# Tween Bridge Solar Farm

## 9.4 Statement of Common Ground with the Environment Agency

**Document Reference: 9.4**

**Revision 2**

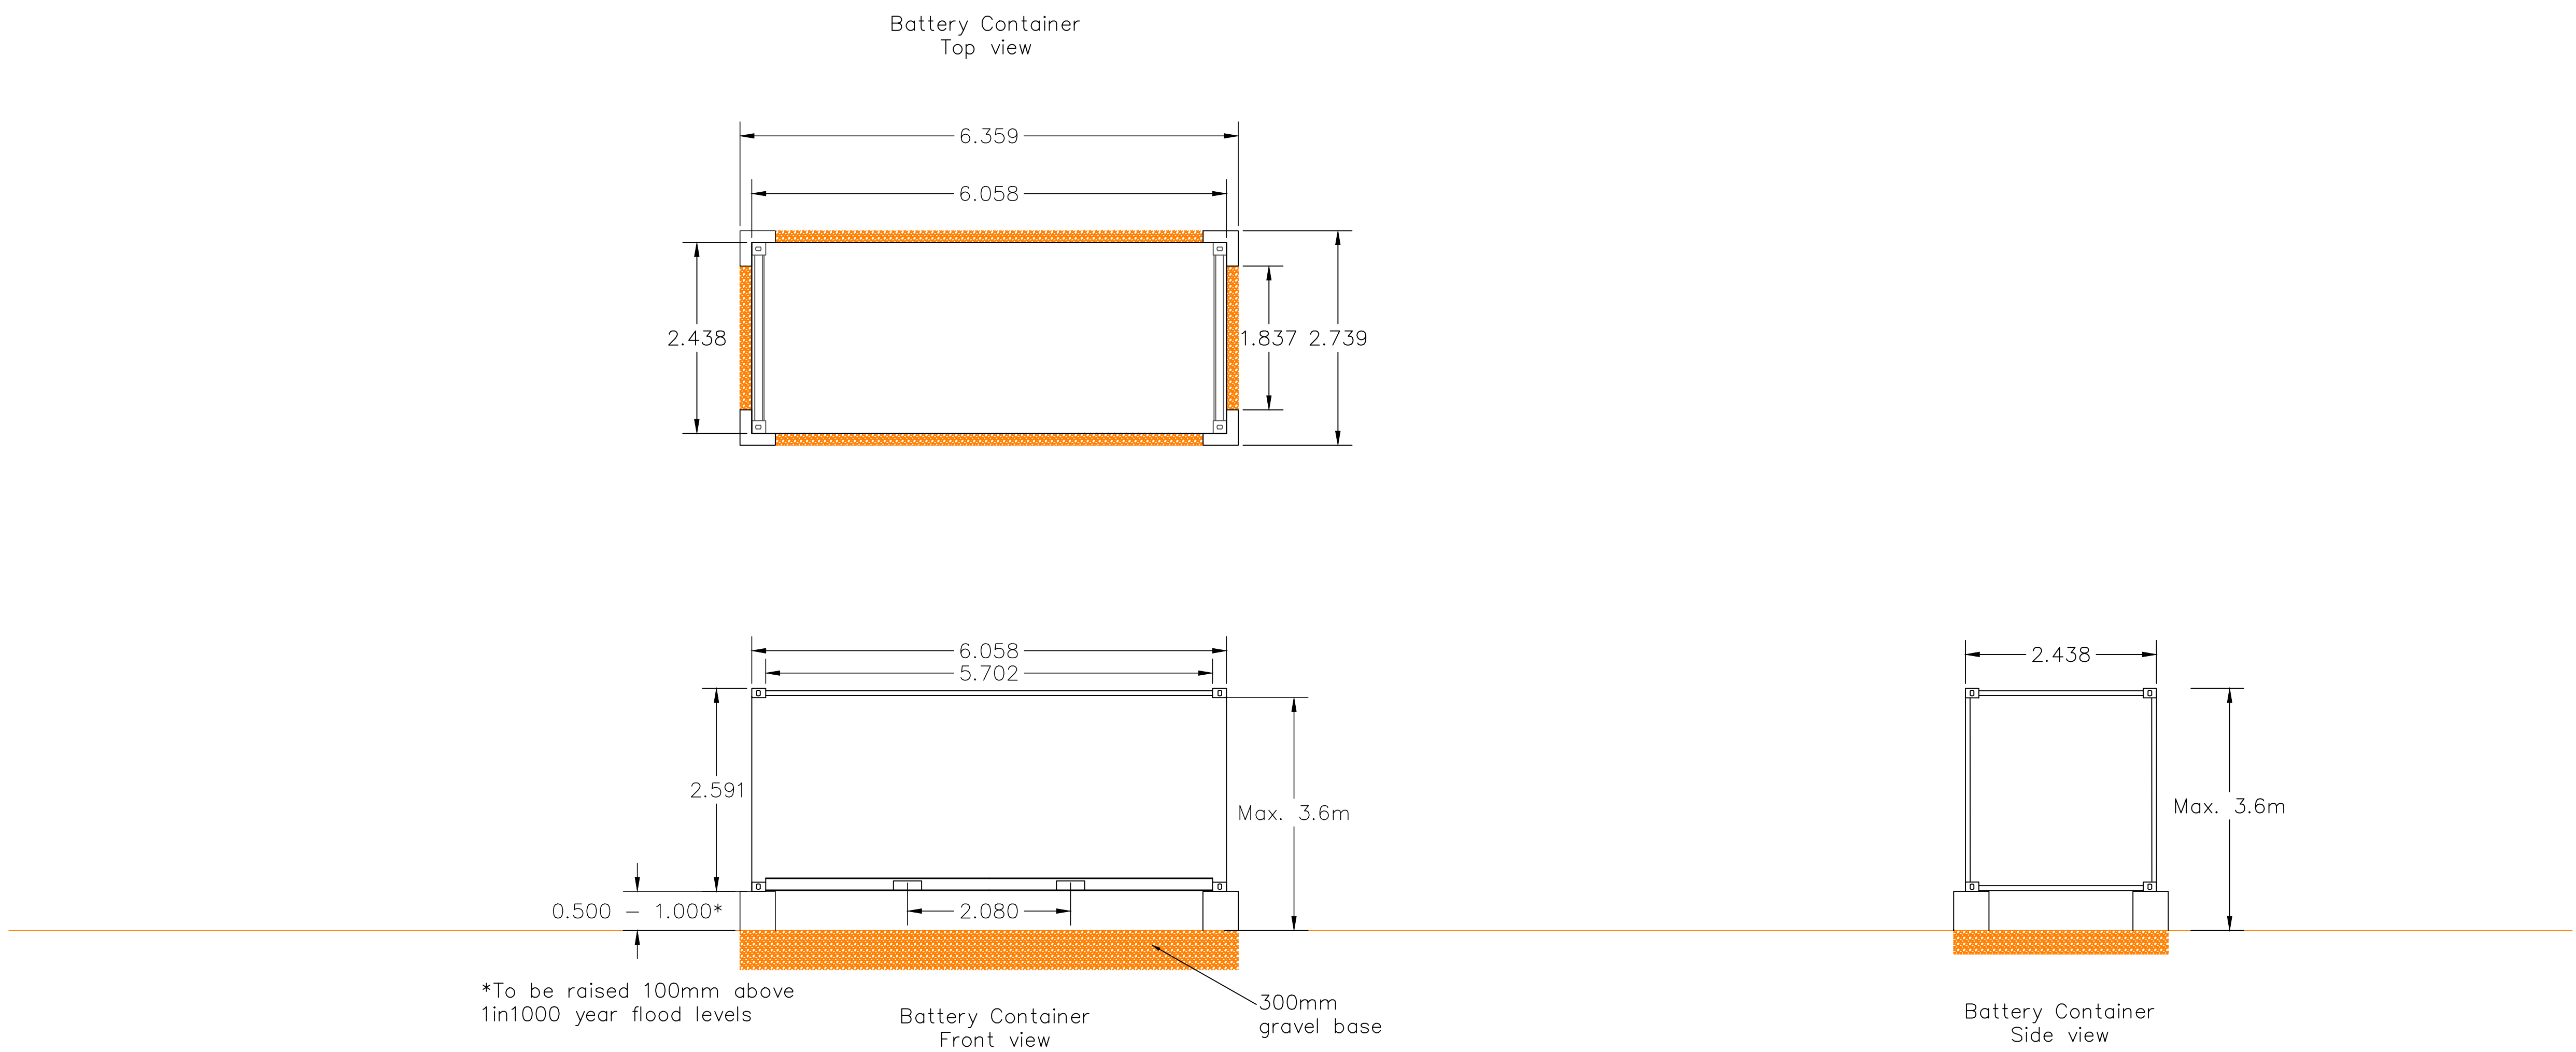
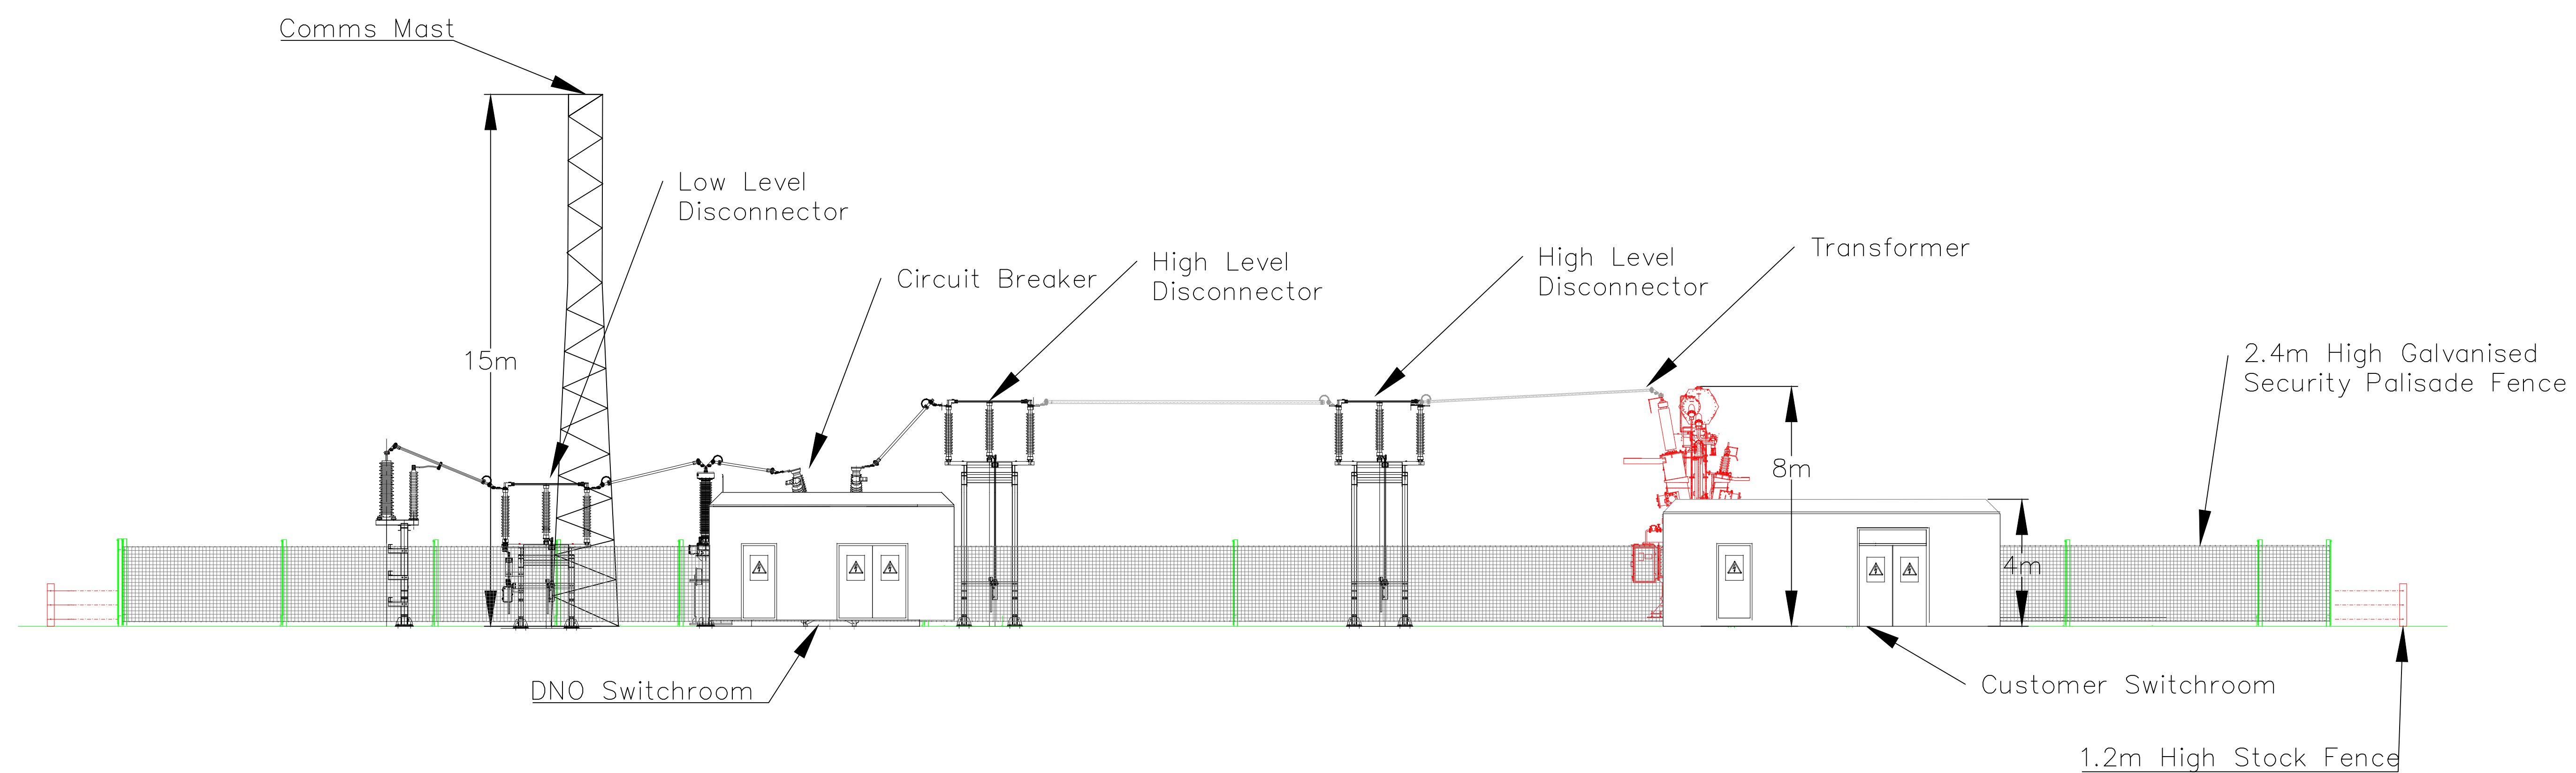
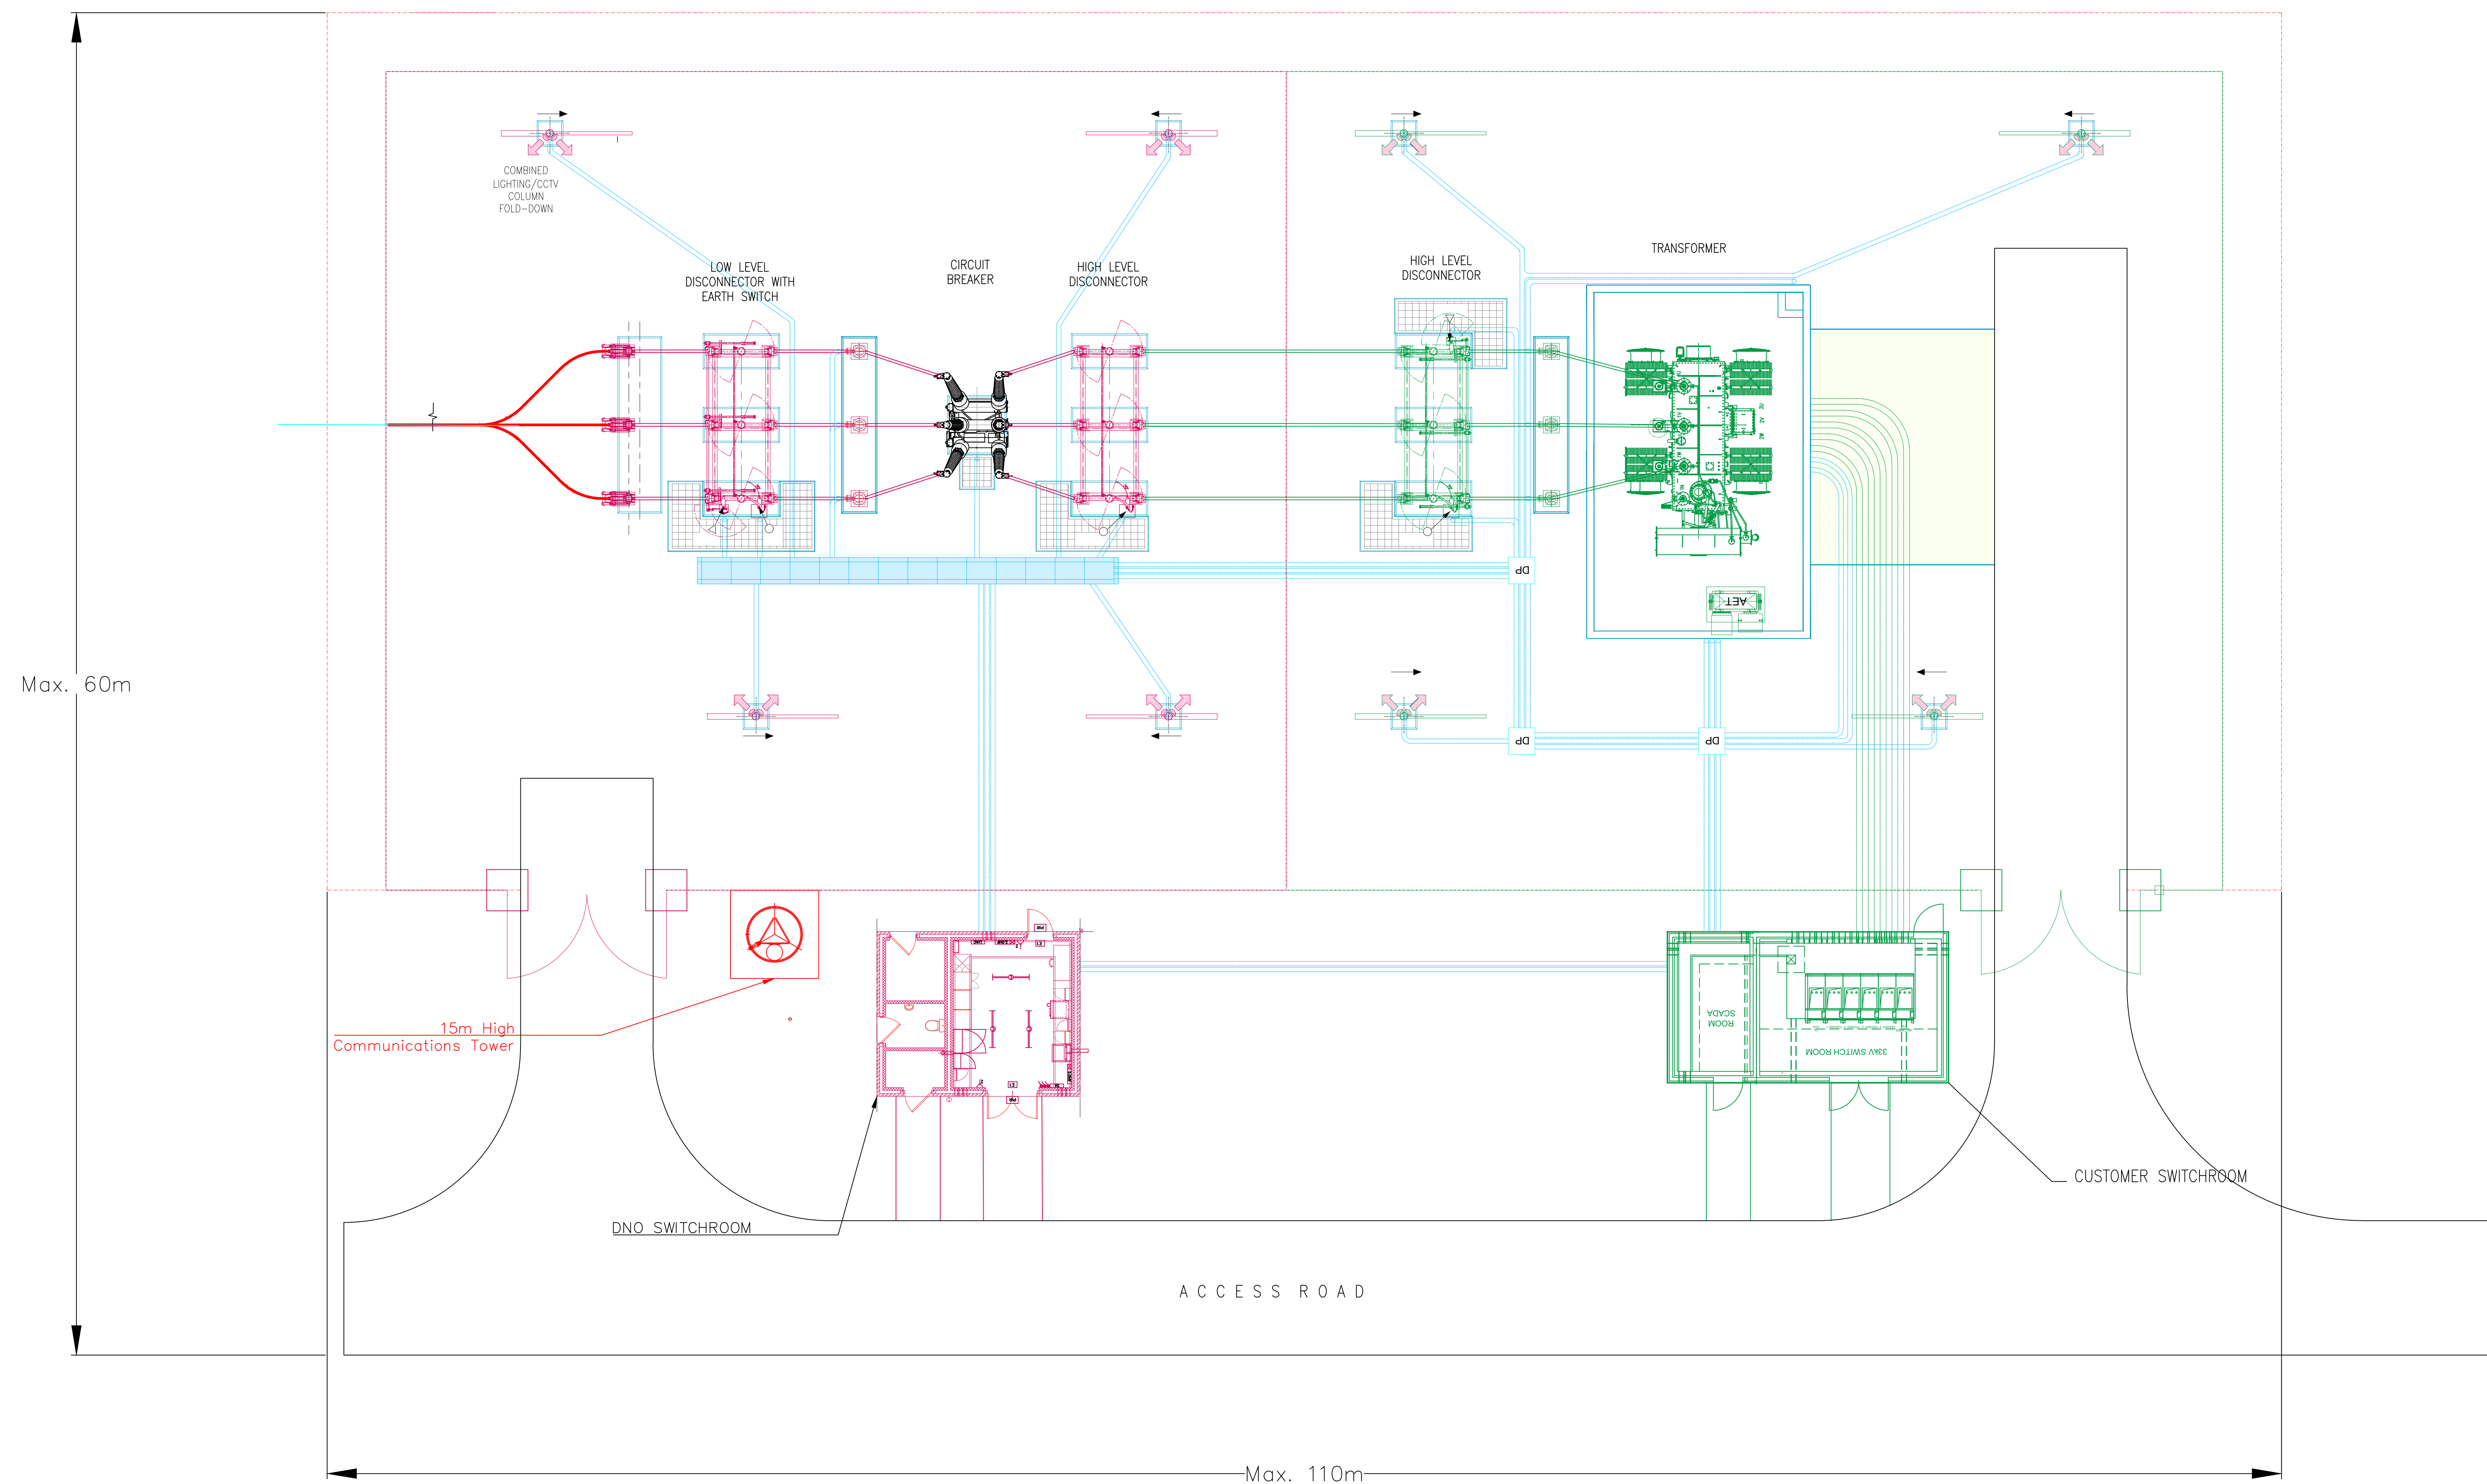
Ref	Topic	EA Position	Applicant Position	Status
10.	Raised Access Tracks	<p><b>Appendix C [APP-108]</b> drawing reference: 'Figure 2.6, Typical Access Track, Rev 1' shows two 'No-dig (non-intrusive)' access track options that will involve the raising of tracks to 0.35/0.4m above the existing ground level. Whilst we acknowledge that the access tracks will be permeable by nature, we consider that there could be a potential impact on flood flows and flood storage. This does not appear to have been considered in the FRA. The FRA concludes that there will be negligible impact on the existing floodplain storage, however, this conclusion has not been fully explained/justified. Further details to support this conclusion and demonstrate that the worst-case scenario has been assessed should be provided. This must demonstrate that there will be no impact to third parties from the proposed development.</p> <p>Alternatively, we would support a commitment in the FRA that any access tracks in the River Torne 1% AEP plus climate change flood extent will not be raised above the ground level, as shown in Figure 2.6 as the 'typical access' options. If the Applicant is able to confirm that there will be no raising</p>	<p>The Applicant has reviewed the location of access tracks within the most recent 2025 River Torne 1% AEP plus climate change flood extent. The number of access tracks requiring raising is anticipated to be limited to a small number of locations (i.e. two locations), and therefore the impact on the floodplain is expected to be minimal.</p> <p>The Applicant had a meeting with the EA in March 2026 to present the locations where raising is proposed and to seek agreement on an appropriate approach moving forward. The Applicant has since provided further evidence to confirm that flood flows will not be displaced to third-party land and will remain contained within the Order Limits. This further evidence is included within the submitted Flood Risk Assessment <b>[REP2-047, REP2-049 and REP2-051]</b> within paragraphs 5.34-5.38 and Appendix A13 and A14.</p> <p>Within their Comments on any further information requested by the ExA and received by deadline 1 document <b>[REP2-102]</b>, the Environment Agency state: " Appendices A13 and A14 include drawings of the proposed</p>	Agreed

Ref	Topic	EA Position	Applicant Position	Status
		<p>of tracks within the relevant River Torne extent, this will resolve our holding objection in respect of the potential increase in flood risk to third parties.</p>	<p>raised track locations within the River Torne extent. As previously advised, the loss of floodplain should be calculated up to the 1% annual exceedance probability plus climate change flood event. We have reviewed the drawings, and we are satisfied that the proposed track raising will not increase flood risk to third parties. Accordingly, we require no further details on this matter, which is now resolved. Accordingly, we withdraw our previous objection and consider that the Applicant has now adequately demonstrated that there will be no increase in flood risk to third parties resulting from the proposed development."</p> <p>Based on the above, this item is agreed between the parties.</p>
